**Subject: DEVIATION REVIEW AND DECISION FORM**

Subdivision or Project Name: The Gardens at North Carefree Final Plat

Section of ECM from Which Deviation is Sought: \_\_ECM Figure 2-17: Typical Urban Local Cross Section\_\_\_\_\_  
 Specific Criteria from Which a Deviation is Sought: \_Meandering Sidewalk and sidewalk outside of r.o.w.\_\_\_\_

Section of ECM from Which Deviation is Sought: SECTION 2.3.4, TABLE 2-14  
Specific Criteria from Which a Deviation is Sought: RATE OF VERTICAL CURVE, K

(URBAN LOCAL) - FALLOW LANE
RUNNING DEER WAY N.T.S.

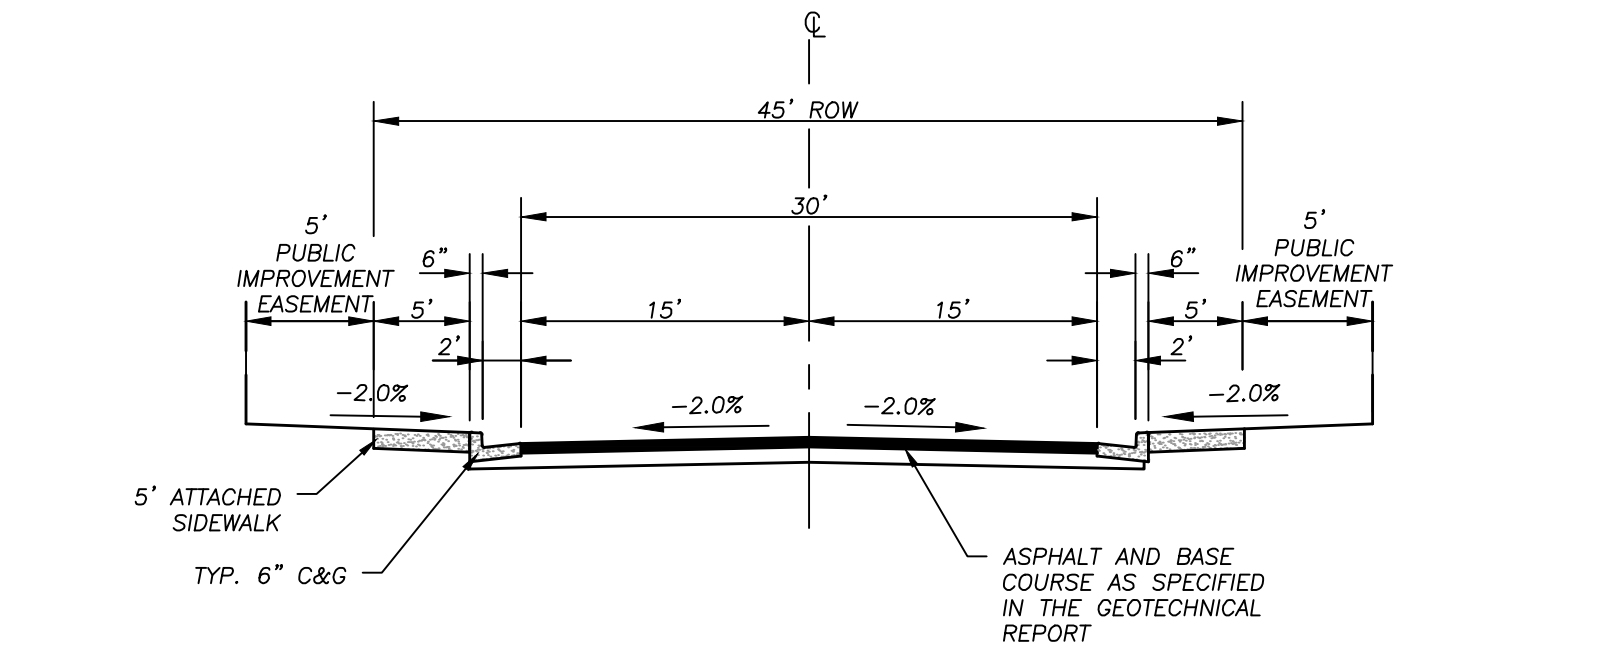
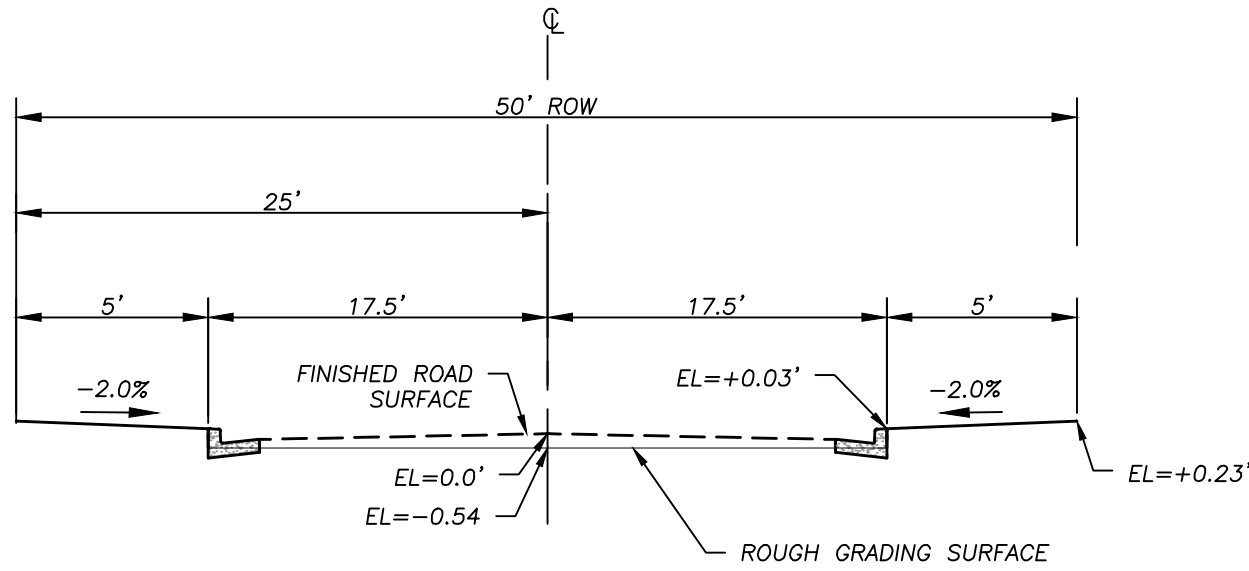
Please indicate the roadway that each of the K values is associated with.

Proposed Nature and Extent of Deviation: The 2 access roads to the project (Running Deer Lane and Fallow Lane) cannot meet the minimum K value requirements for vertical curves in part to the short segment of each road and driven by the requirement to treat 100% of storm water on site and the requirement to provide a 2% cross slope at the intersection with Akers Drive to meet ADA standards for cross walks. The K factors being used are 9.5 and 7.71 at the crest and 15.42 in the sag; required K factor are 12 at the crest and 26 in the sag curves.

Proposed Nature and Extent of Deviation: The 2 access roads to the project (Running Deer Way and Fallow Lane) cannot meet the minimum K value requirements for vertical curves in part to the short segment of each road and driven by the requirement to treat 100% of storm water on site and the requirement to provide a 2% cross slope at the intersection with Akers Drive to meet ADA standards for cross walks. The K factors being used are 9.5 and 7.71 at the crest and 15.42 in the sag; required K factor are 12 at the crest and 26 in the sag curves. Access is only allowed to Akers Drive

SHEET 14 OF 34

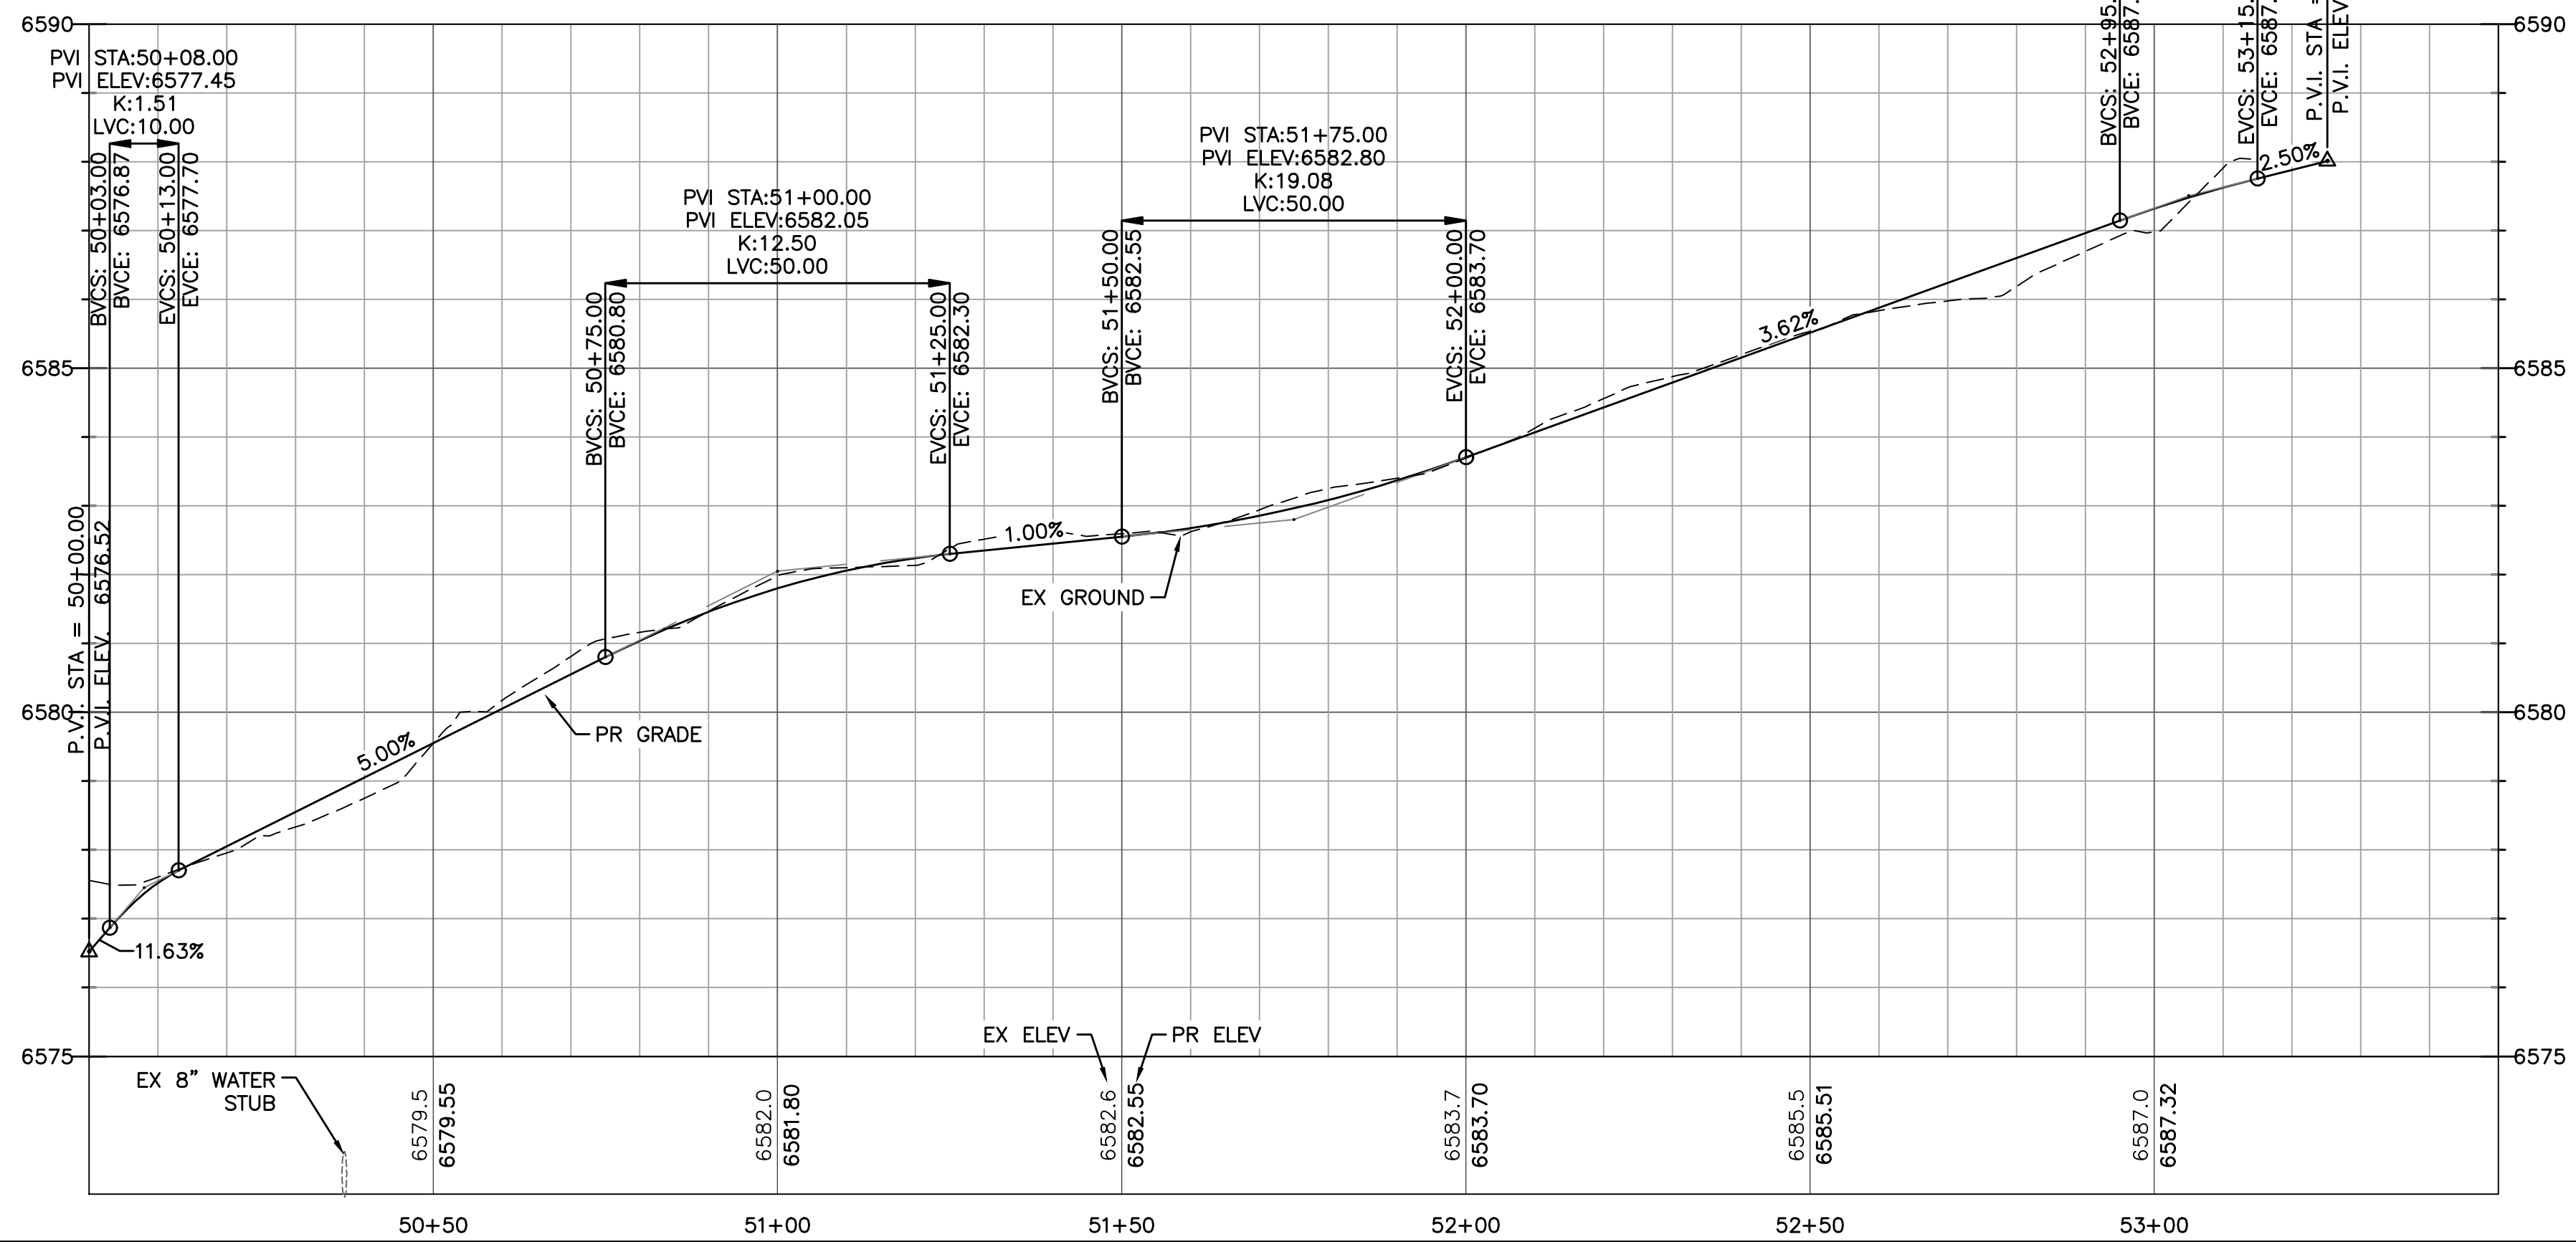
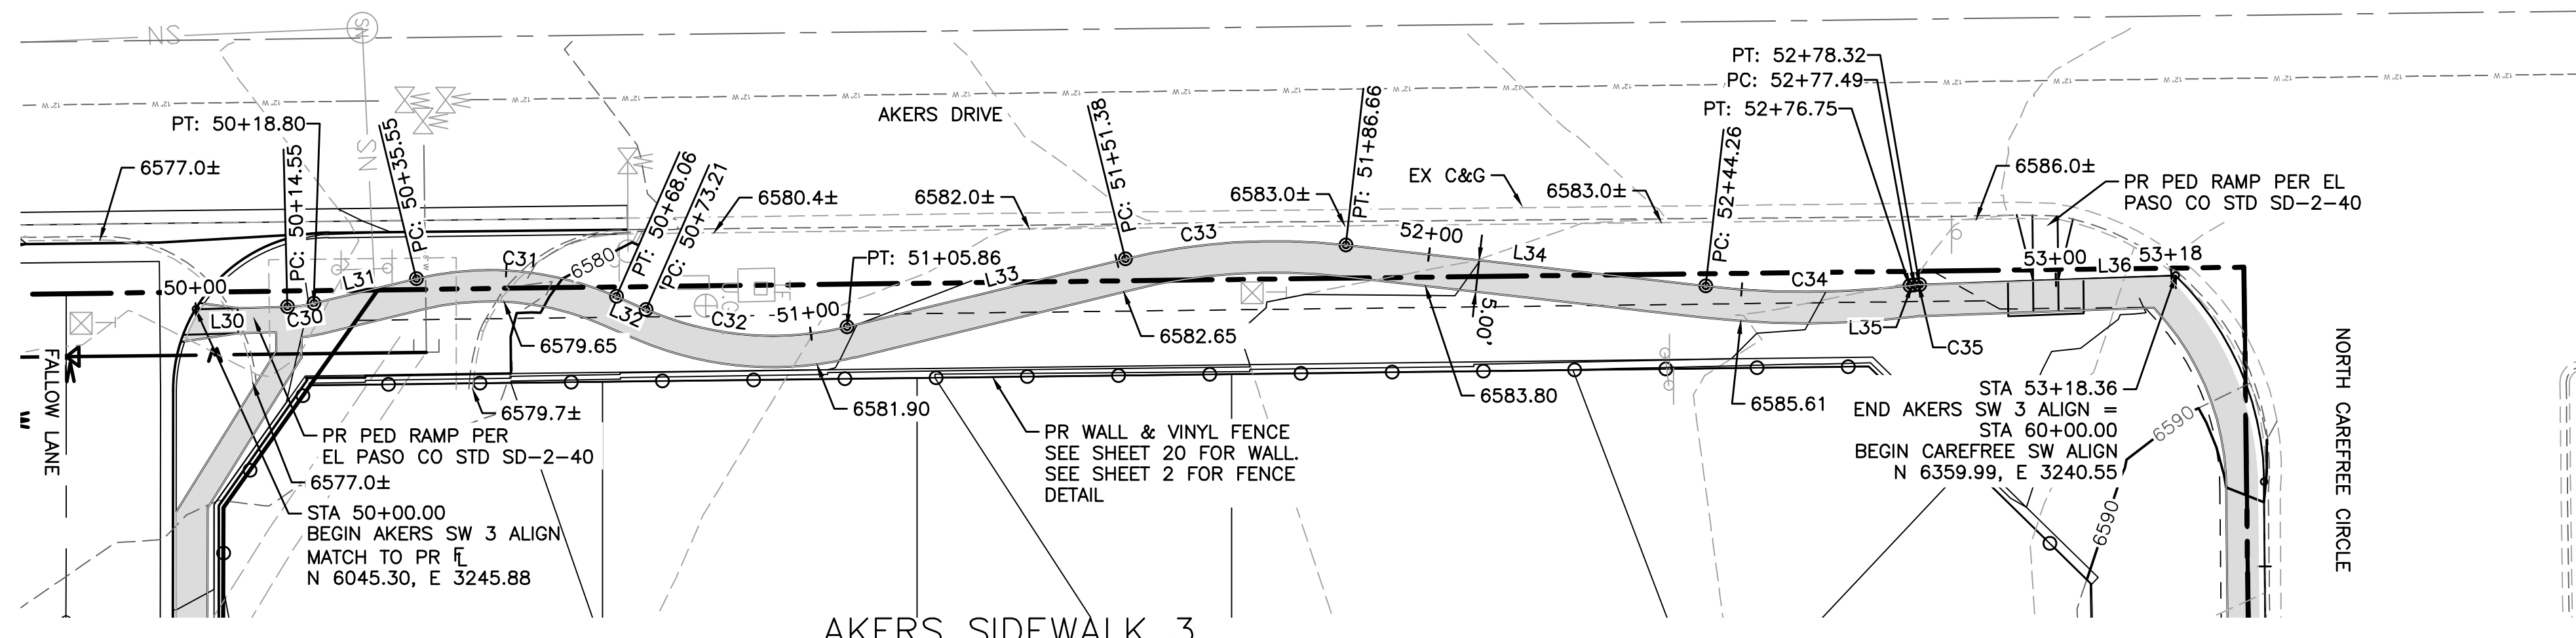
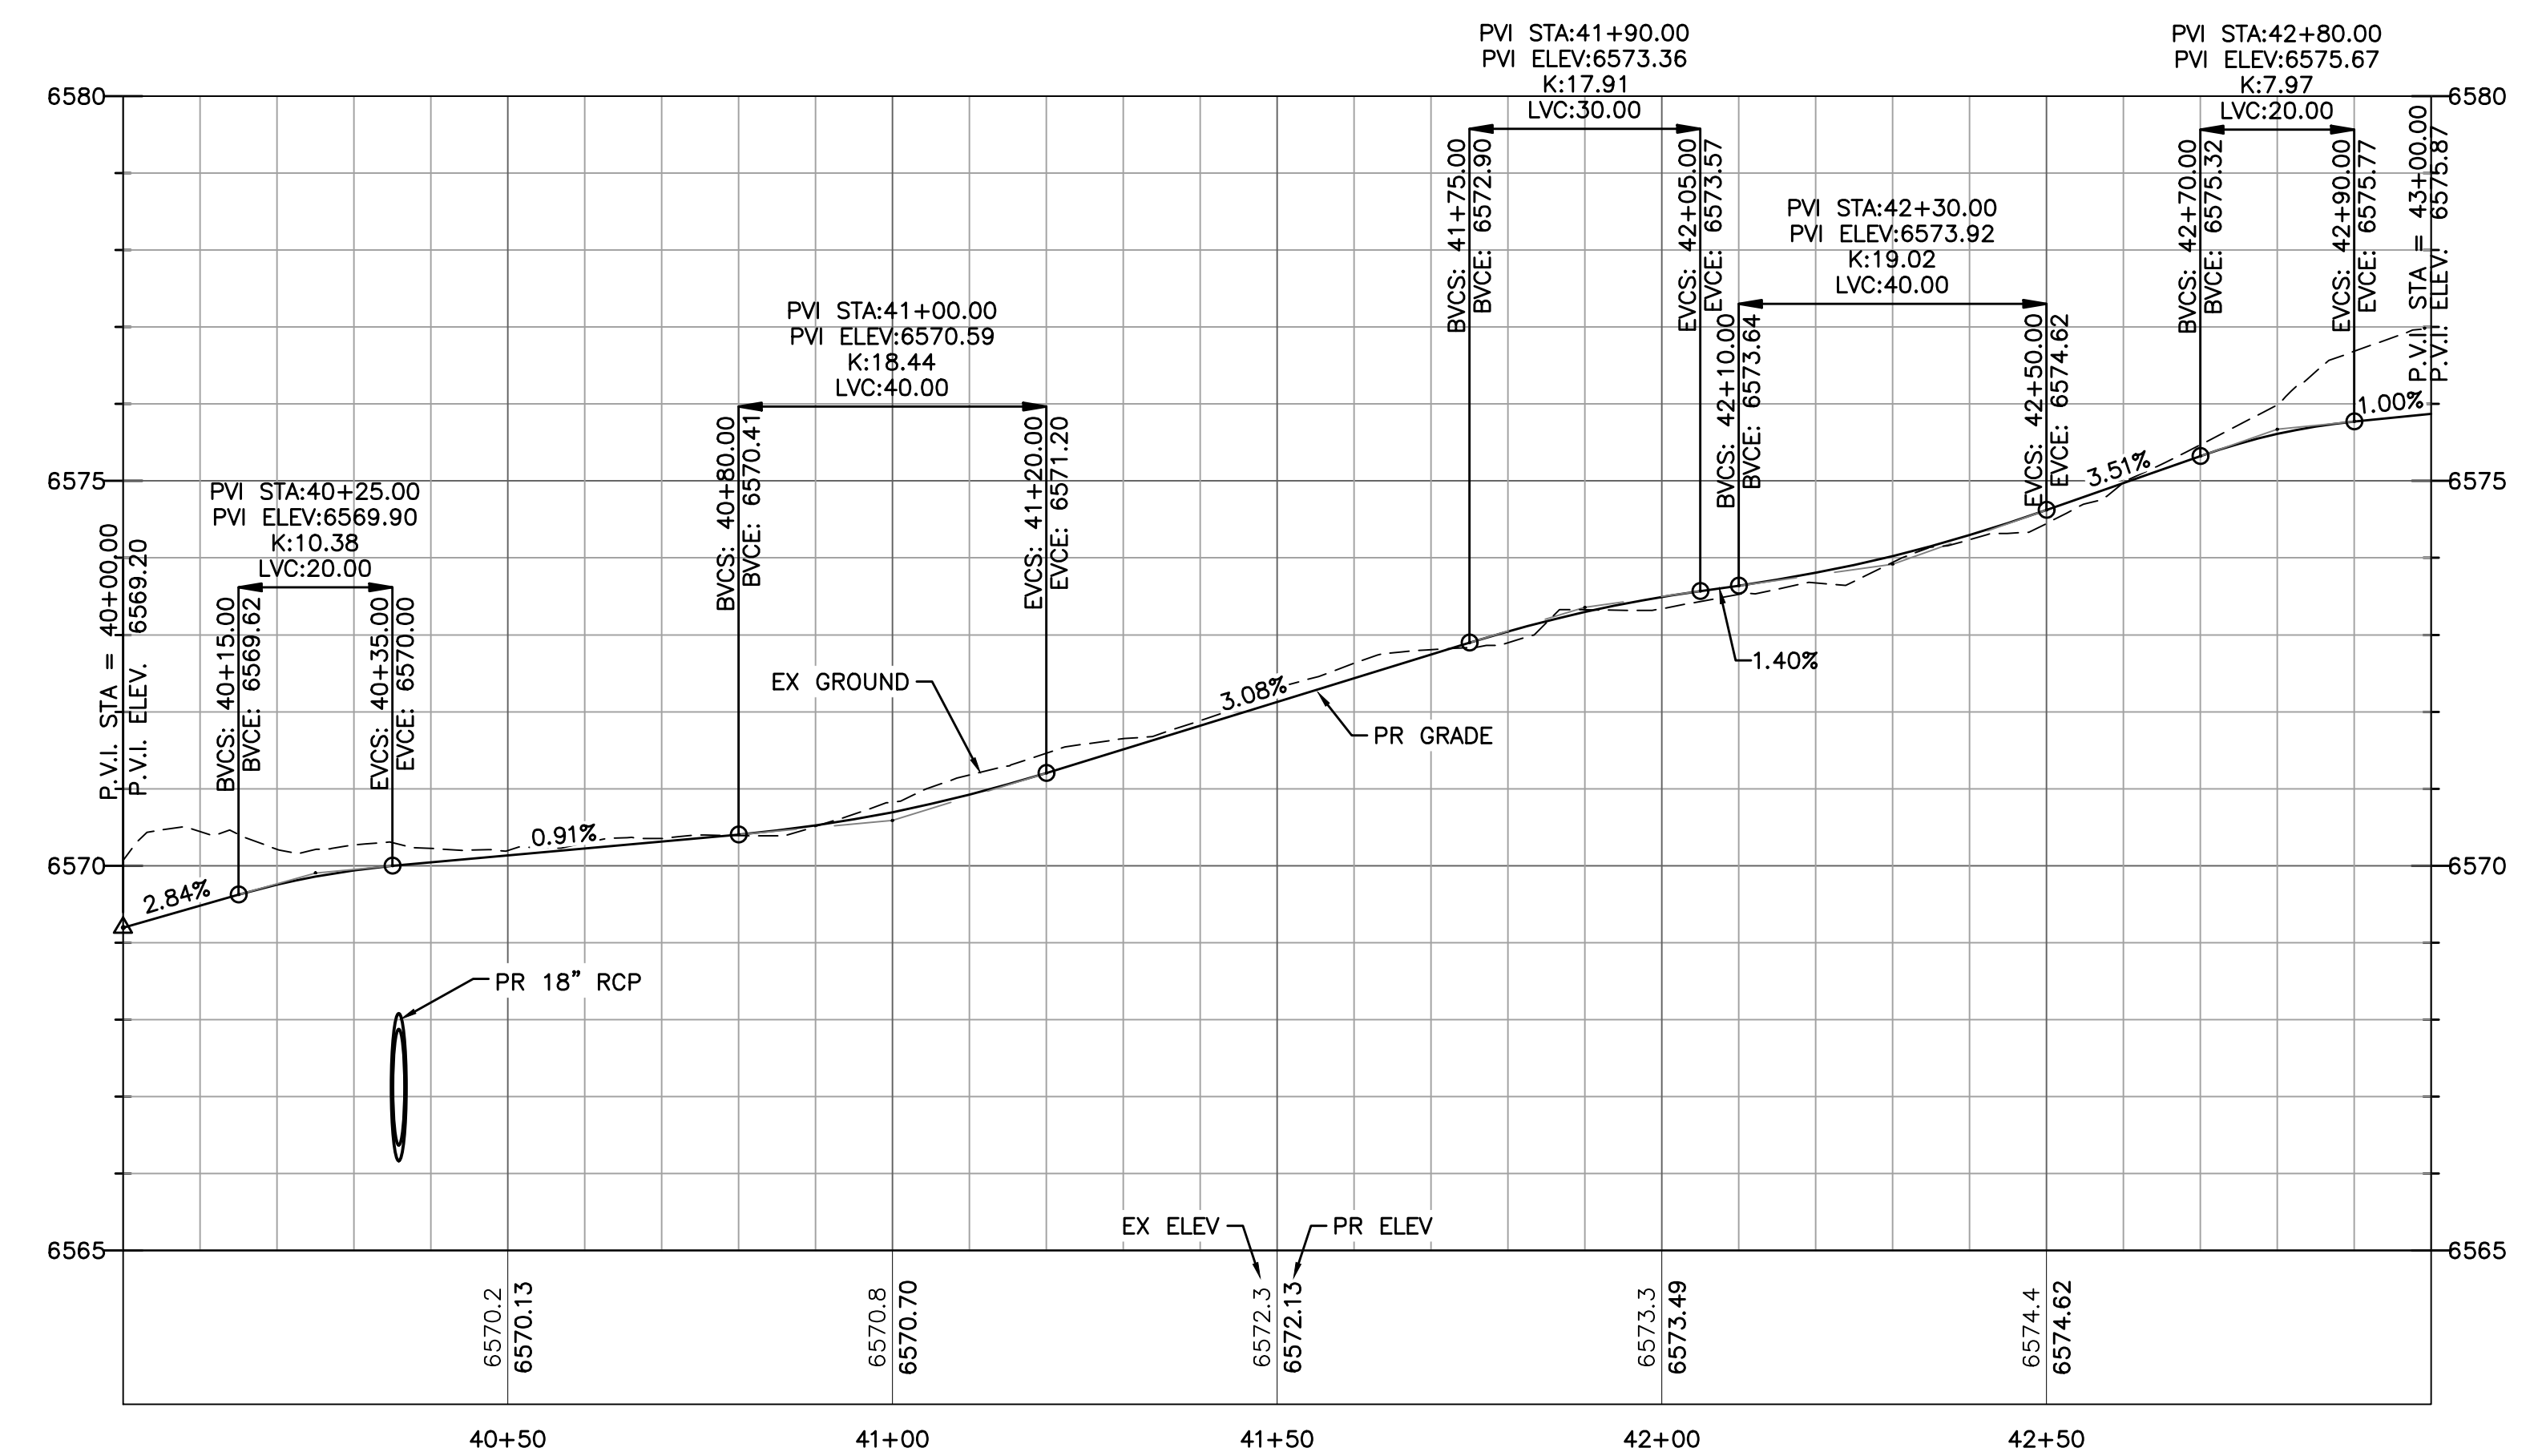
Akers drive is a non residential collector. Revise

Proposed Nature and Extent of Deviation: \_Project owner is proposing a tract adjacent to the Akers r.o.w. for landscape and sidewalk. Owner proposing meandering sidewalk with landscape for a more appealing corridor for the proposed development\_\_\_\_\_

Section of ECM from Which Deviation is Sought: \_ECM Figure 2-17: Typical Urban Local Cross Section\_\_\_\_\_  
 Specific Criteria from Which a Deviation is Sought: Allow for a meandering sidewalk in rather than a sidewalk parallel to the curb. Sidewalk to be partially in r.o.w. and partially in an easement. \_\_\_\_\_

Proposed Nature and Extent of Deviation: \_Meander from within 2' of the curb to 6' of the curb\_\_\_\_\_
